From: Gedney, David
Sent: 27 April 2015 15:23
To: _planningadvice
Subject: FW: Condition Compliance Application H13-0211-15 - Wind turbine, Snake Hall Cottage, 105 Eaugate Road, Moulton Eaugate - REG Wind Power
Attachments: CEL-LI-25-DCW-PCFL-low-intensity-obstruction-warning-light.pdf; Details 28.2.2015.pdf

Subject: Condition Compliance Application H13-0211-15 - Wind turbine, Snake Hall Cottage, 105 Eaugate Road, Moulton Eaugate - REG Wind Power

I write in relation to the above condition compliance application and request clarification in respect of the following matters:

Drawing Title:
Dulas 50m mast: 50m,
40m, 30m

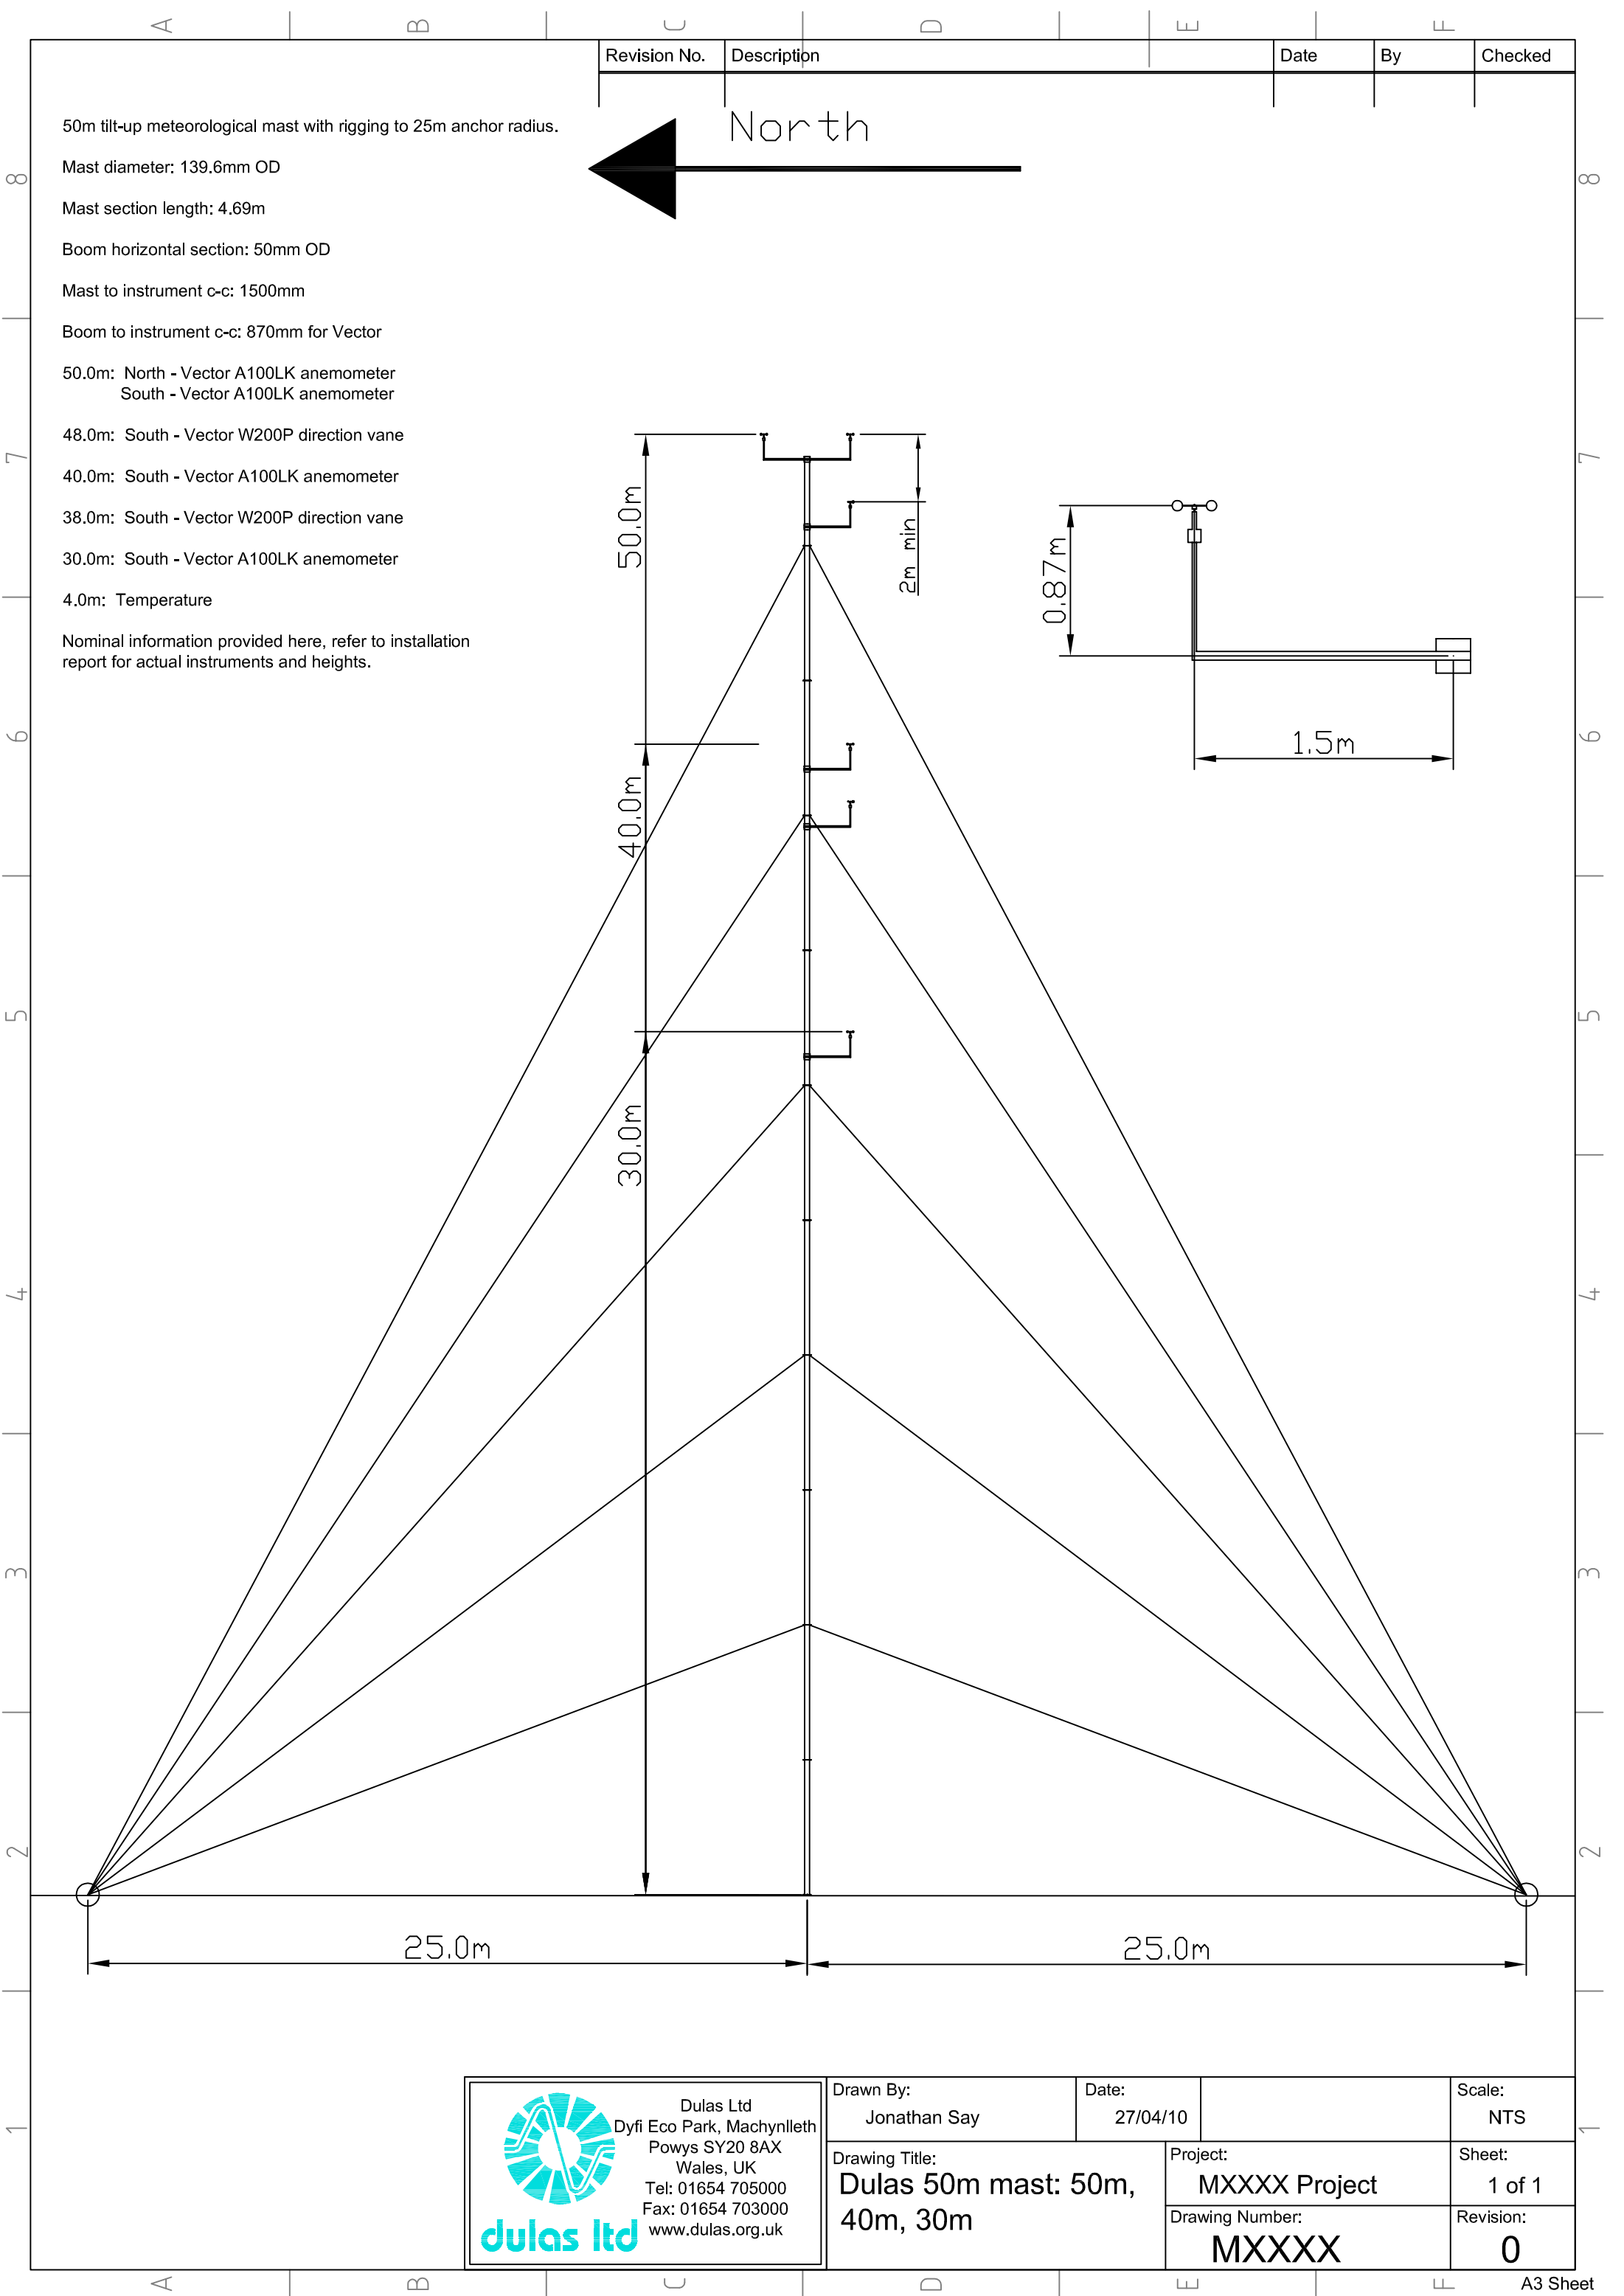
- 1) Will the whole of the turbine be white? The original drawings indicated that the lower section of the tower would be a different colour.
- 2) The new planting adjacent Eaugate Road appears to be within 9 metres of a South Holland Internal Drainage Board. Unless the SHIDB is agreeable it will need to be repositioned at least 9m from the brink of the drain.
- 3) Condition 20 requires aviation lighting in respect of the temporary anemometry mast. However, such details do not appear to have been submitted.

1. As confirmed, the RAL colour is noted on the site layout
2. A fully revised landscaping plan is attached
3. Our client's specification for aviation lighting to the anemometry mast is attached.
